Application for Planning Permission for Works or Extension to a Dwelling

Development Single storey rear extension & garage conversion
Location 4 Pine Walk Bognor Regis

Block Plan REV01
Scale 1:500

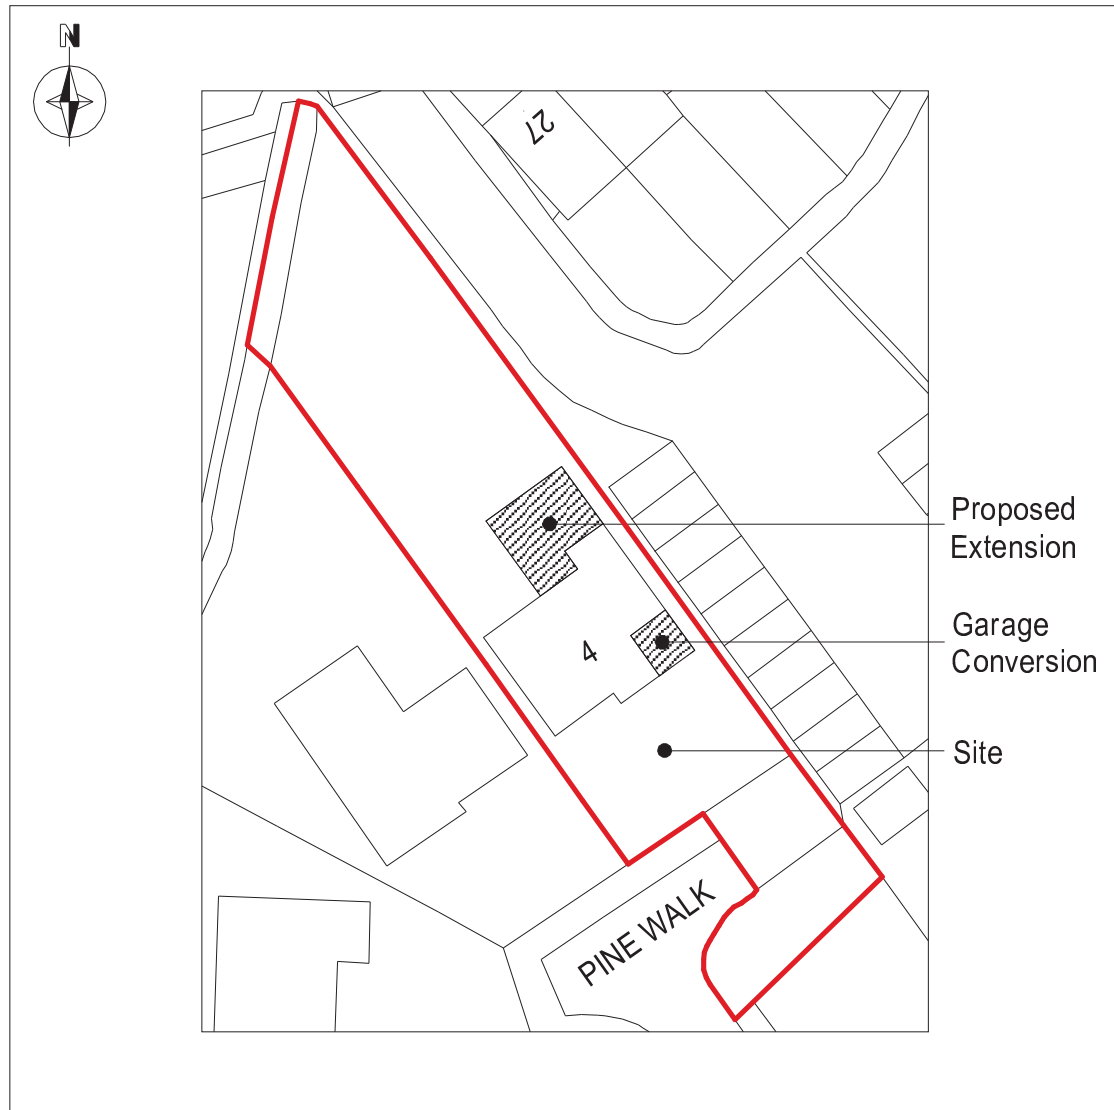
Please submit 1 electronic or 3 paper copies of a revised block/site plan showing all the proposed works, in accordance with the guidance notes available on our website detailed below (click on National List).
